**A303 Amesbury to Berwick Down  
(Stonehenge) Wiltshire  
TR010025**

**Wiltshire Council (A303-AFP022)  
Written Summaries of Oral Submissions  
put at the Issue Specific Hearings held in  
August 2019**

Rev
P03

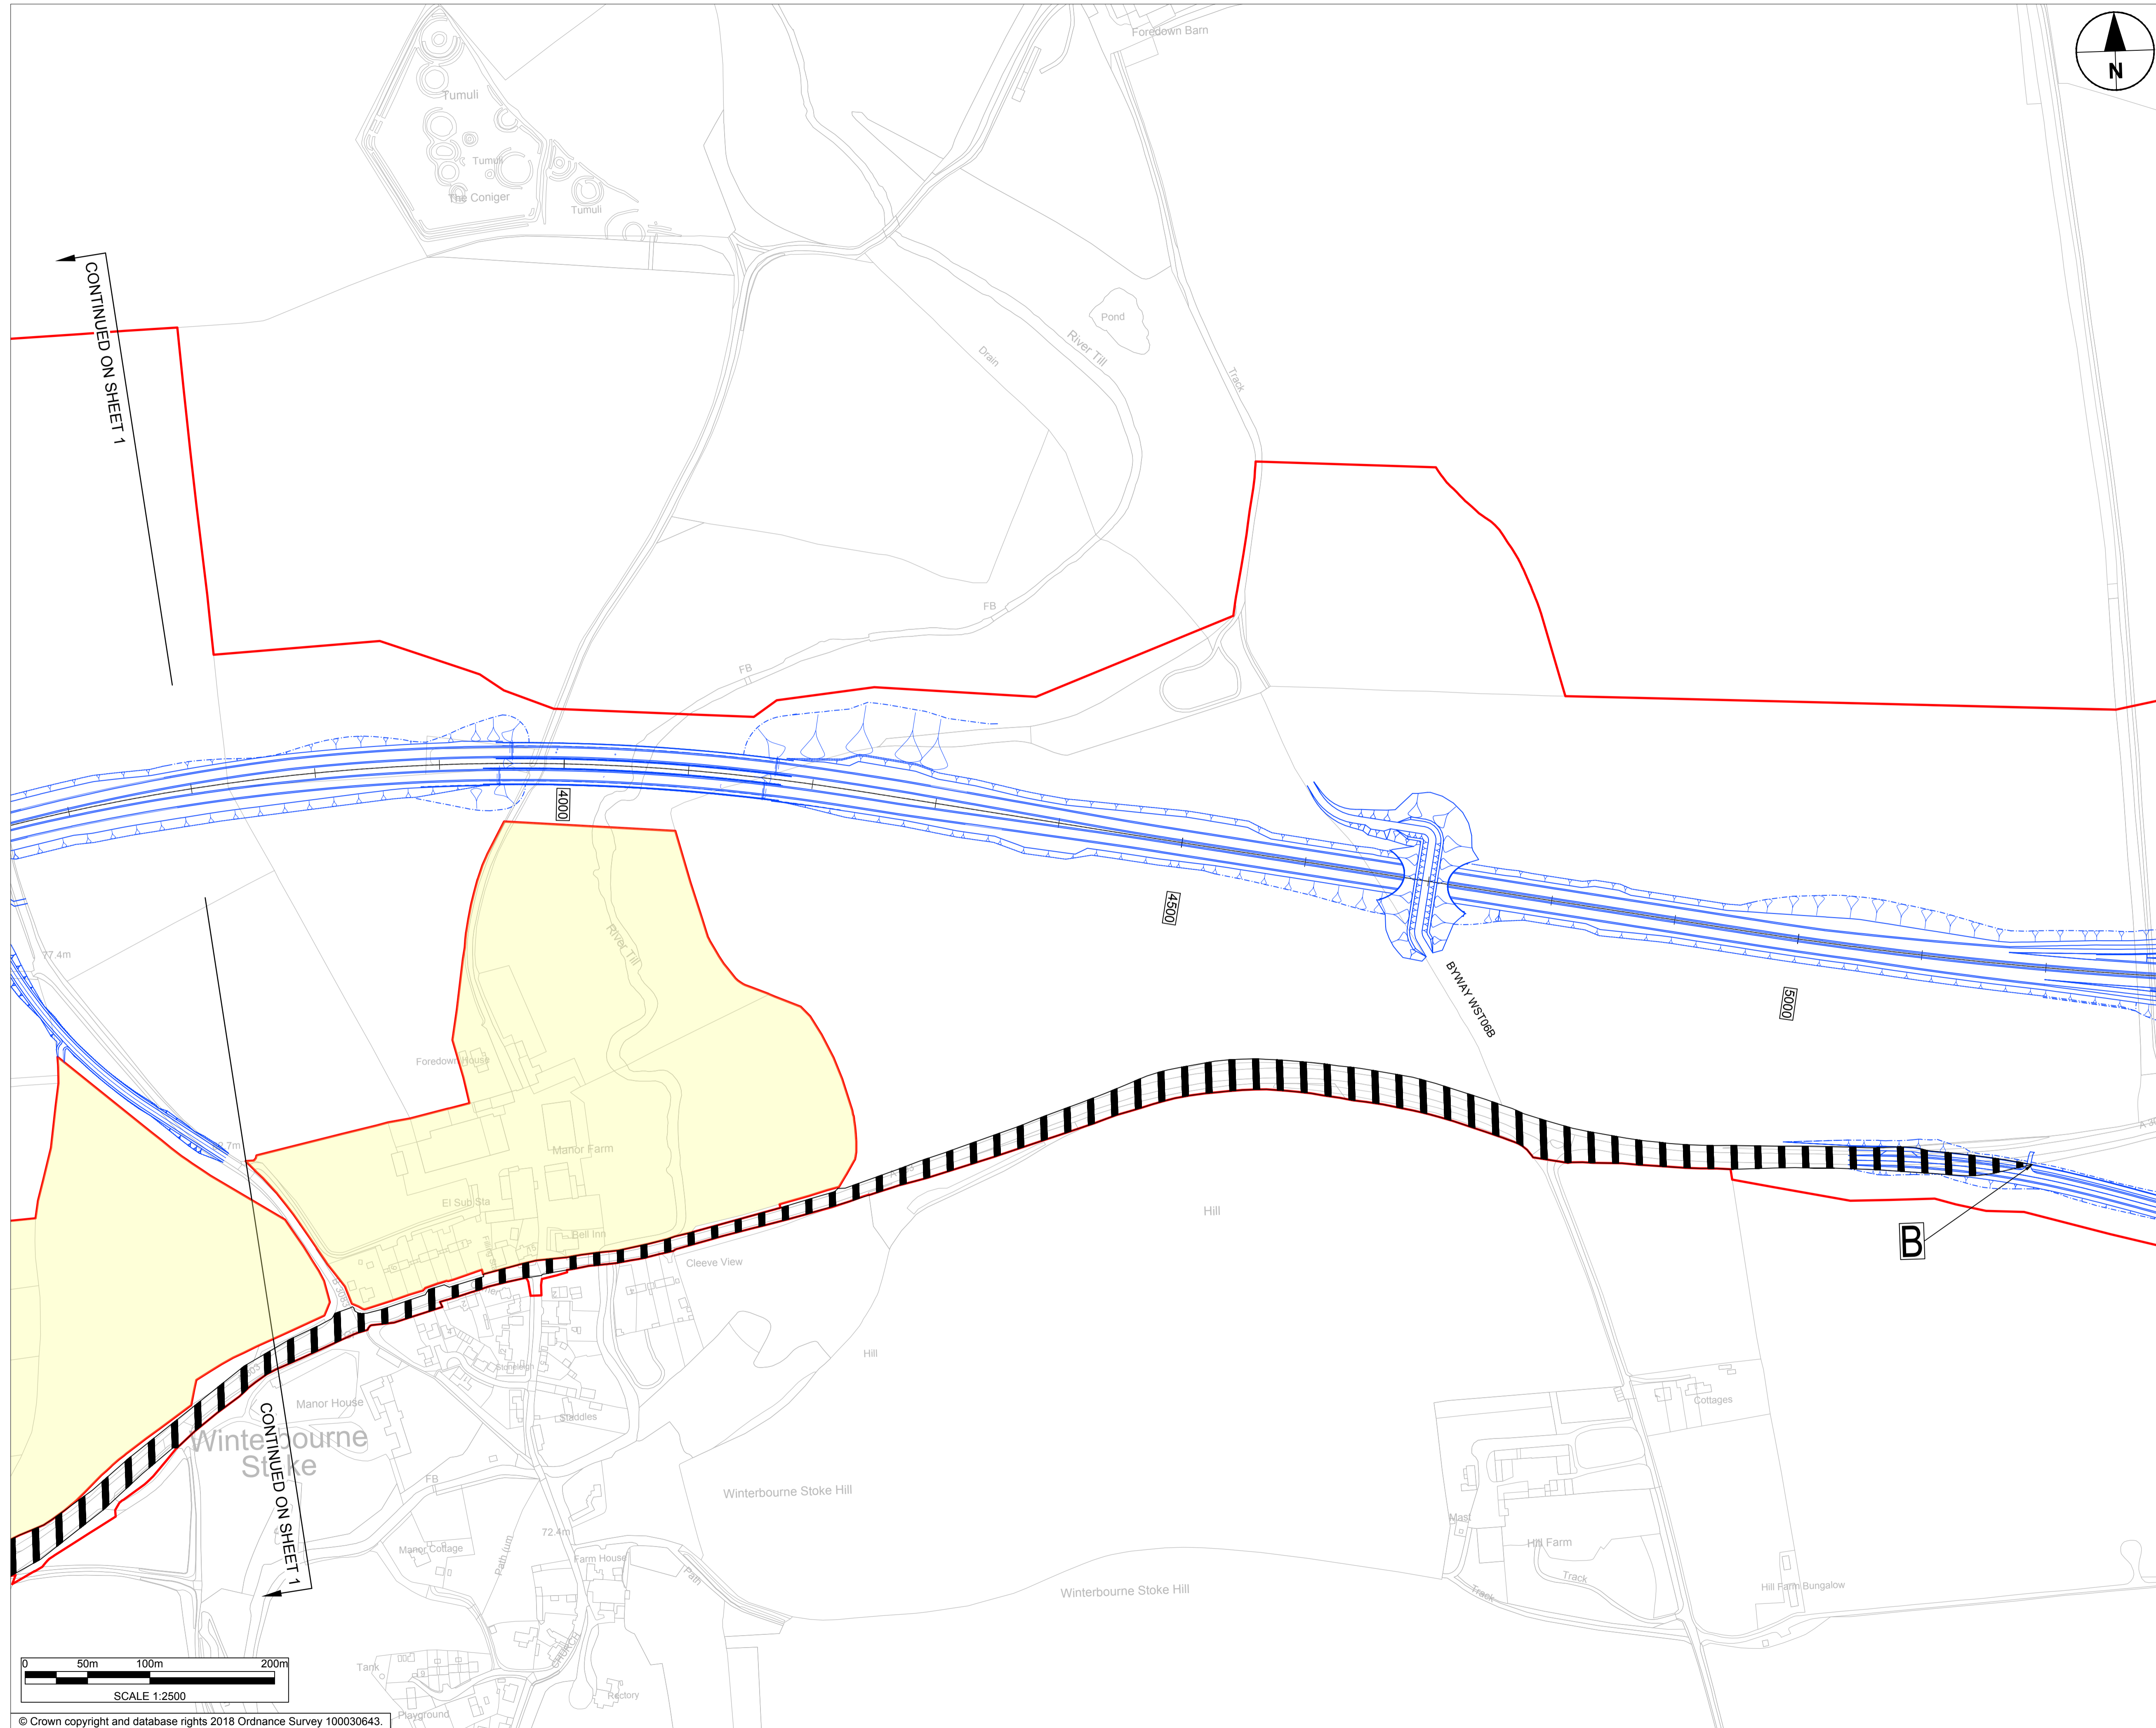
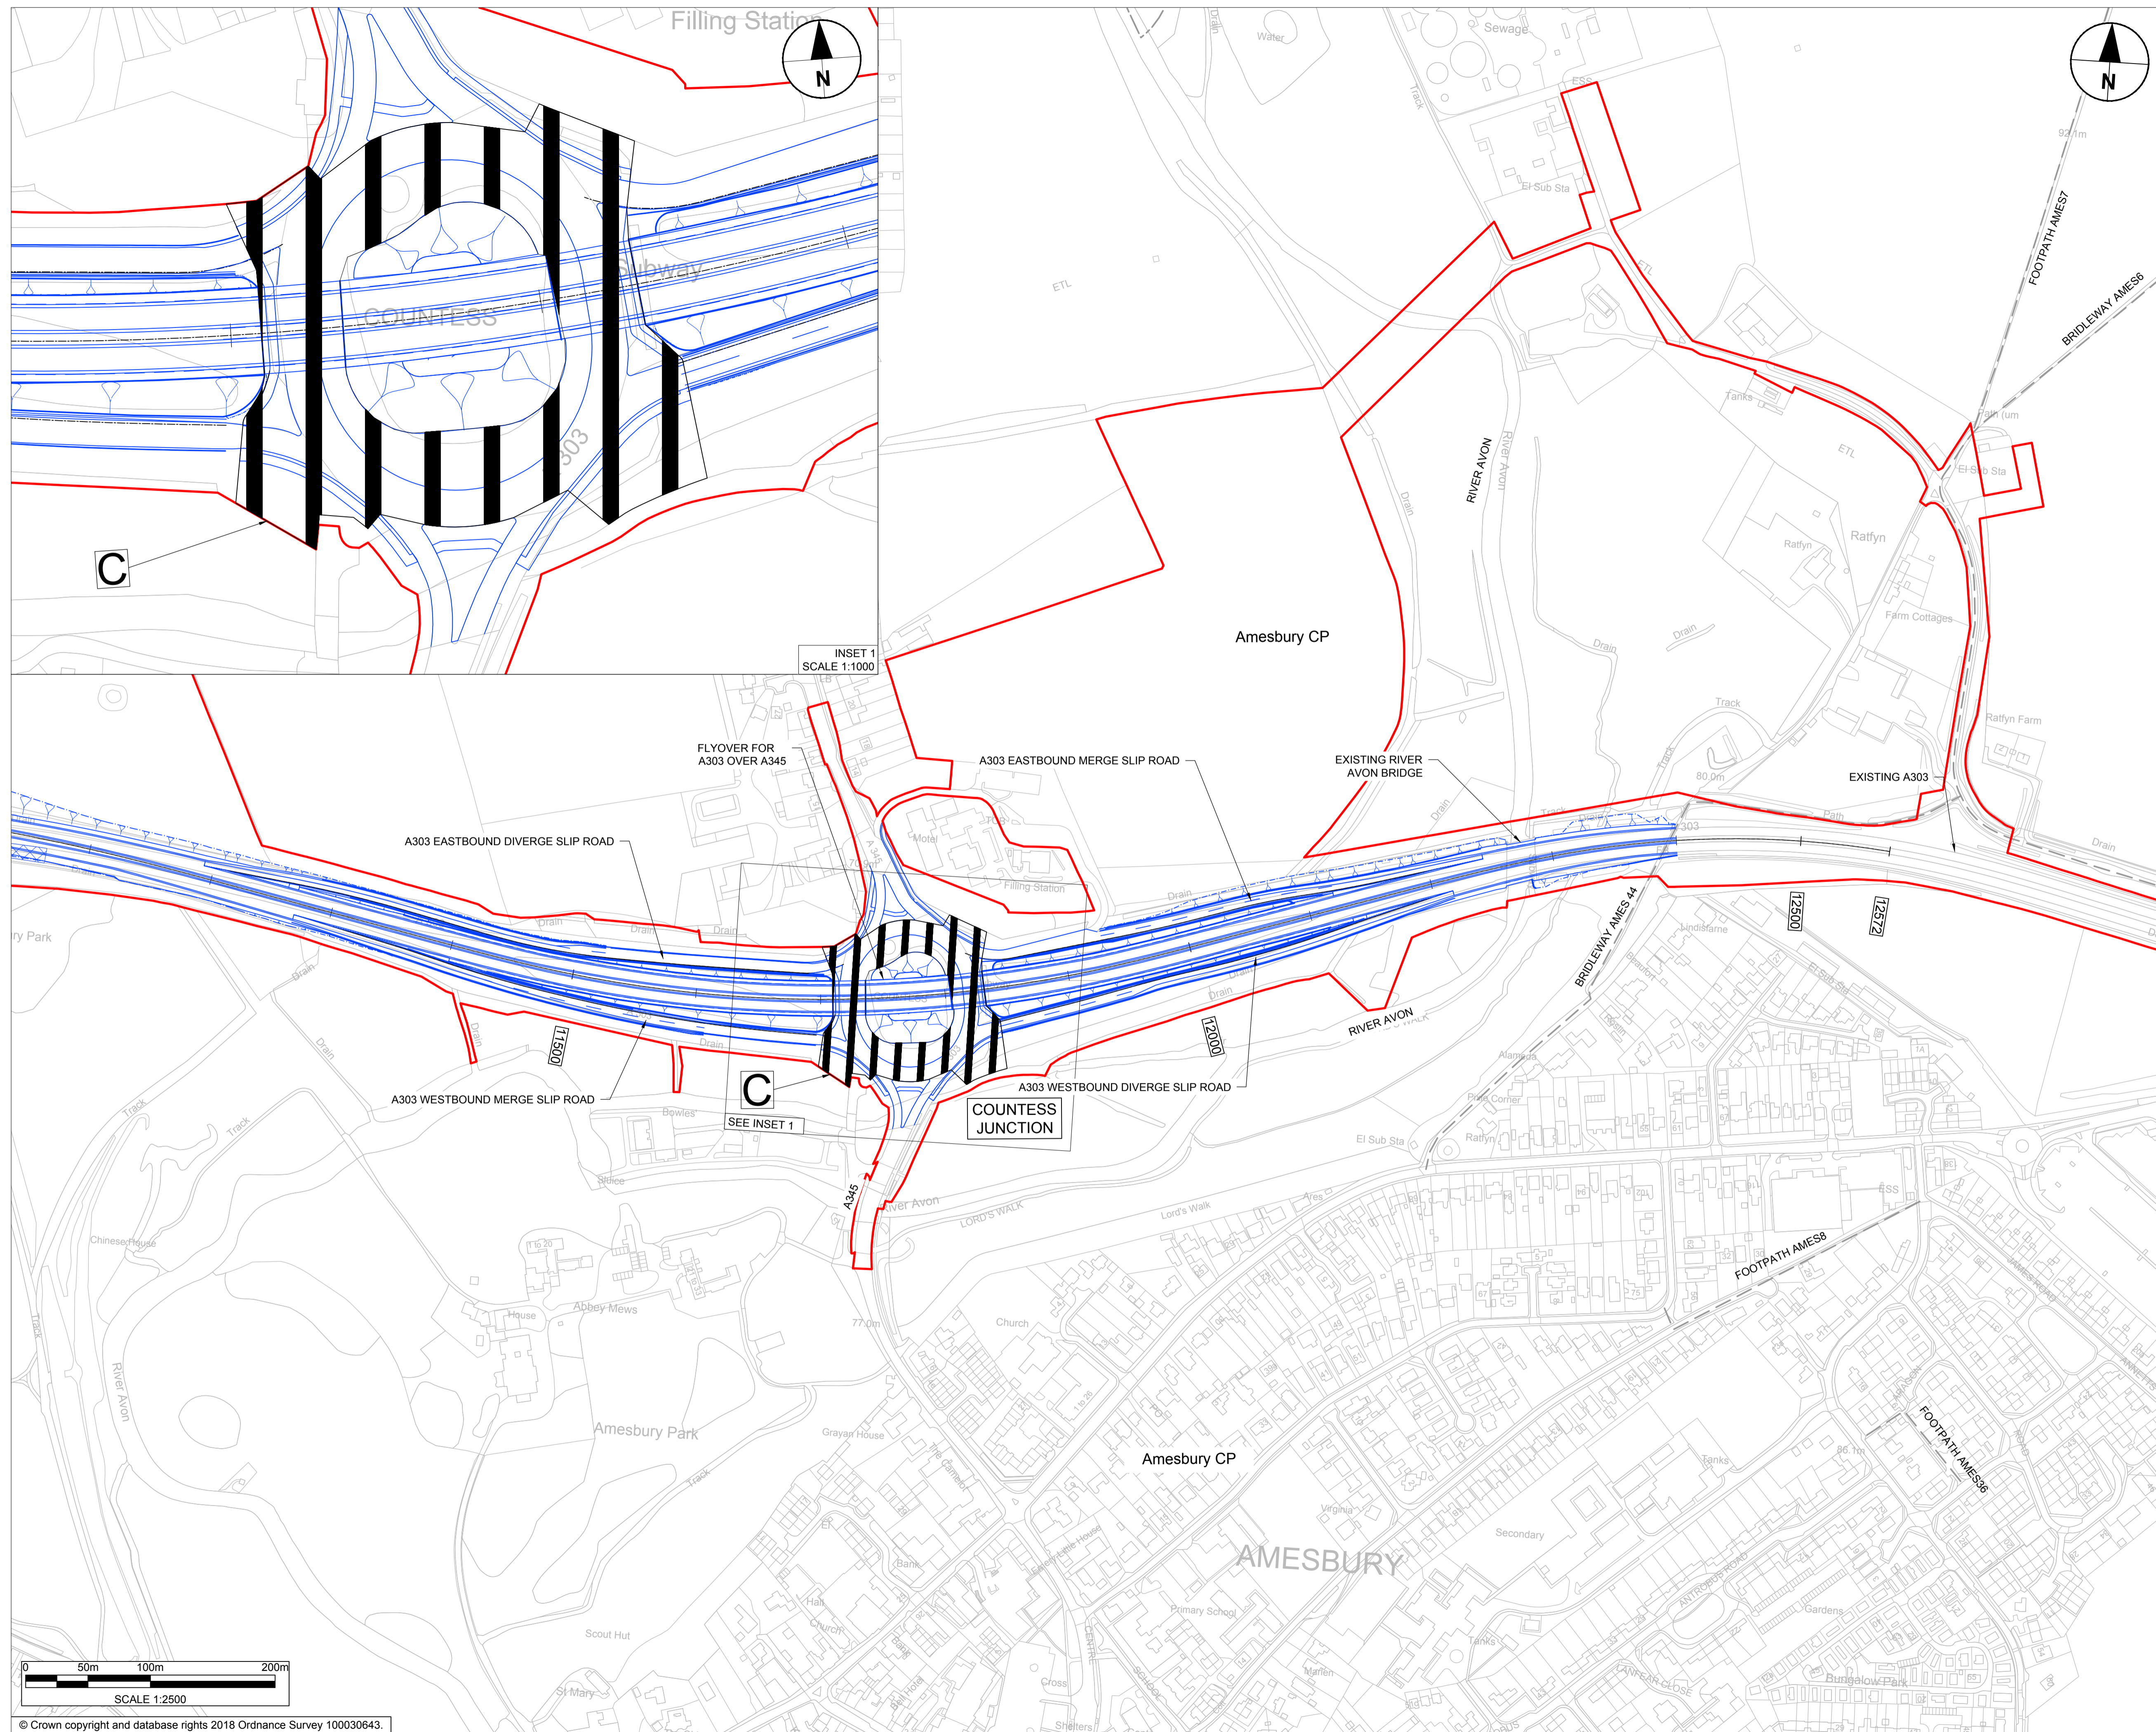
2.2.1 The Council confirmed that it supports proposed change NMC-02 in principle, however the precise boundary between the trunk road and local roads needs to be confirmed. The Council also indicated that there were points of detail on the plan legends which required resolution.

“Whilst the proposed change is in line with the general principle put forward by the Council, there is concern about the detail of the area shown hatched black, which excludes verge areas to the north and south sides of the junction, which are currently understood to be trunk road (maintained by HE, not Wiltshire Council), and which should be de-trunked to become verges to the A345 north-south route.

The highways records held by the Council show that there is significant verge area around all parts of the roundabout. The Council would wish to see the de-trunking hatch markings extend into the verge to the north side of the eastbound diverge and merge slips, and to the south of the westbound diverge and merge slip roads. The Council would be happy to agree the precise boundary between the strategic roads and the local roads with HE prior to their finalisation of the de-trunking alterations.

It is noted that the De-Trunking Plans Key Plan will need to be amended to accommodate a Sheet 03, but there is no need to show in the legend ‘Existing A303 to be de-trunked...’ because this detail will be shown on the individual drawing sheet. The change from before to after drawings for the Key Plan, removing the dashed line requires some explanation, but the Council raises no issue as to how the tunnel section of the Scheme is presented on a Key Plan.

The proposed change to the legend, as shown in the consultation document should be changed, for Sheet 03 only, to read ‘Existing A303 to be de-trunked (Area C)’ rather than the proposed ‘Existing A303 to be de-trunked (Area A to B and C)’. The rationale for this is because A to B will occur only on Sheets 01 and 02, and Area C will only be found on Sheet 03.”

Figure 4.1: Tunnel Drainage Schematic

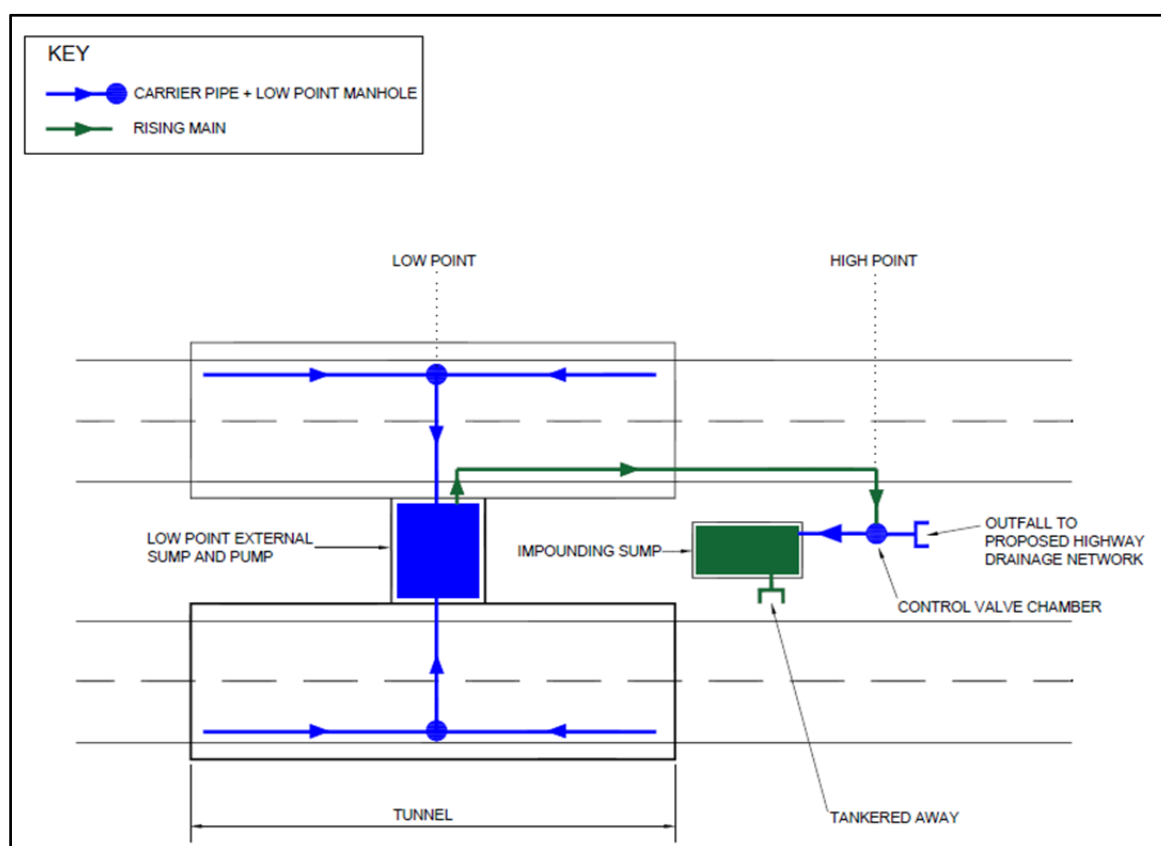
- 3.2.3 With regard to agenda item 3.2 ii, the Council confirmed that it was still its position that controls should be automated. The Council considers automated control to be the most robust form of control, which would limit the response time if a spill incident were to occur. It is also a standard form of control for this type of installation. The Council has had discussions with HE and the Environment Agency, and is in agreement with the Environment Agency when requesting automated controls as it does not rely on human intervention, it can be programmed and it also relates to the previously discussed issue on HD45 regarding the amount of spill volume to be accommodated within the tunnel drainage. The Council considers that there could be less volume of storage provided if the response time was potentially shorter.

- 3.2.4 The Council stated that at the moment there was not a DMRB standard for the control of tunnel drainage, so there is not a fall-back position on standards to refer to. This is why the Council considers that this design parameter should be fixed at this stage. It is also one of the design parameters that the Council proposed for inclusion at MW-WAT14 as outlined during the discussion on agenda item 3.1. The Council is trying to pin down those aspects which it considers is essential during this process, and in the Council's opinion it is inconceivable that there would be a manual mechanism which would be adequate. The Council considers that it would be sensible to make this clear from the outset.
